From: Joanne Moxon [REDACTED]
Sent: 07 March 2014 12:05
To: Anita Gardner
Subject: RE: R/257/13 - Change of Use to Dog Day Care Centre - Unit 2, Phoenix Terrace, Artex Avenue, Rustington

From: Anita Gardner [REDACTED]
Sent: 05 March 2014 10:45
To: 'jo@pawspawstay.co.uk'
Subject: R/257/13 - Change of Use to Dog Day Care Centre - Unit 2, Phoenix Terrace, Artex Avenue, Rustington

Proposed Ground Floor Plan 1:100  
Rev A  
Prepared for Arun District Council  
January 2014

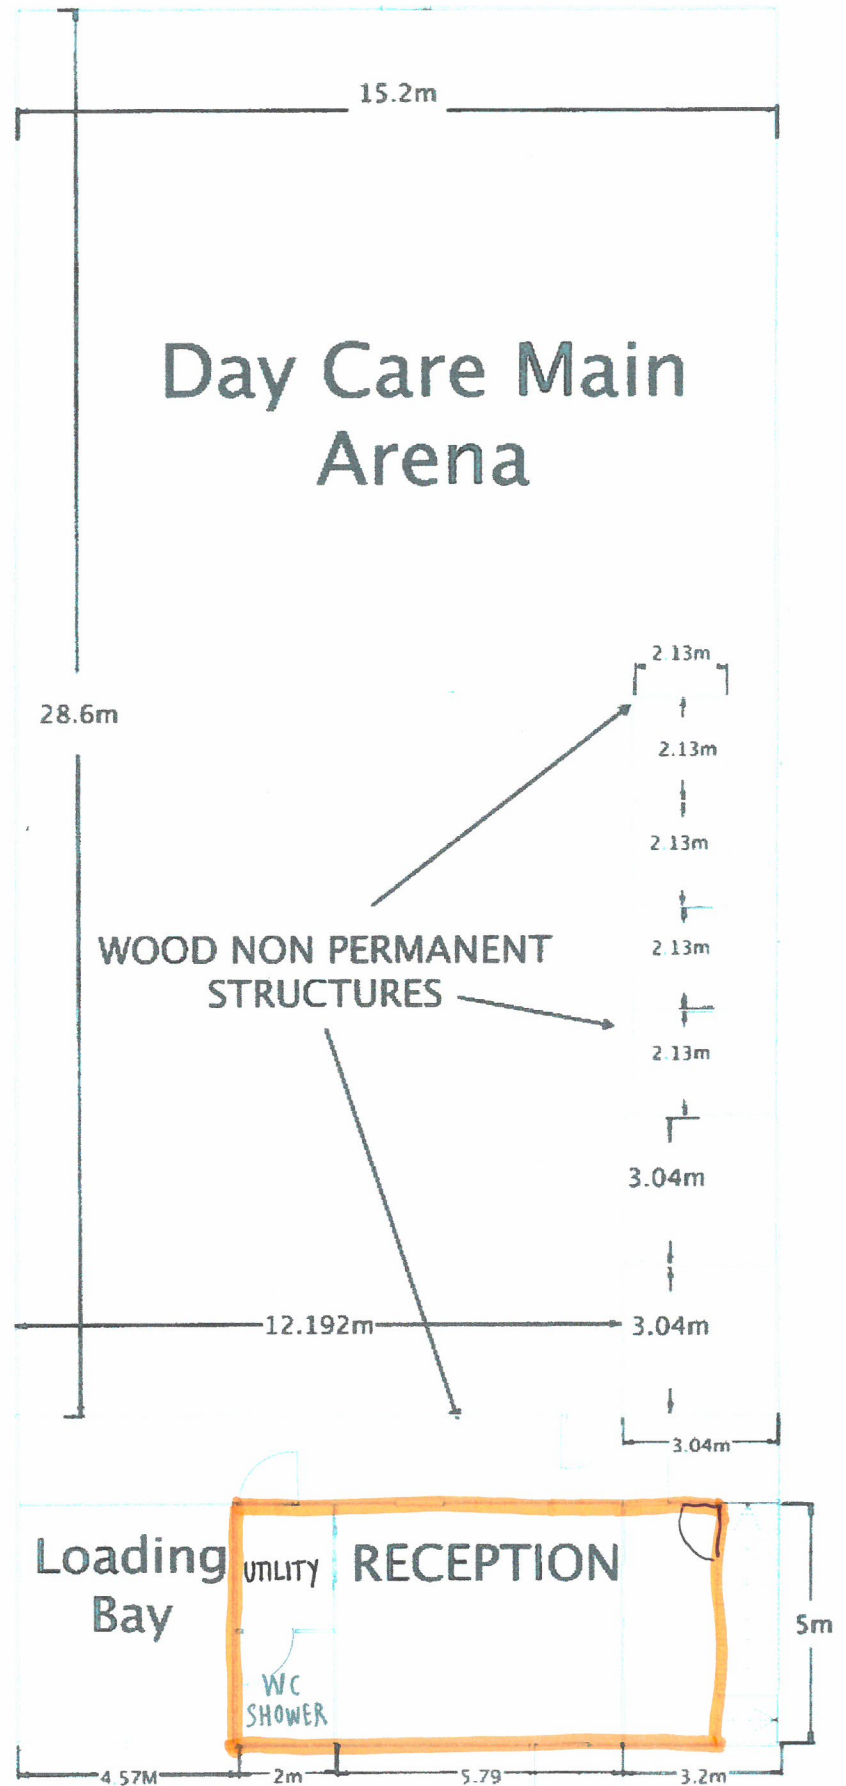
Stairs are indicated on the ground floor layout plan and space above the reception area at first floor exists and is utilised. A first floor layout plan is therefore required to be submitted as part of the application. In addition Q18 of the form refers to a gross internal floor area of 5,000 square metres, but the ground floor plan area measures 35.4m x 15.2m totalling 5,380 and the area of the first floor also needs to be added to this.

Without prejudice, I would therefore appreciate, as a matter of urgency, receipt of a first floor plan and an amended figure in response to Q18.
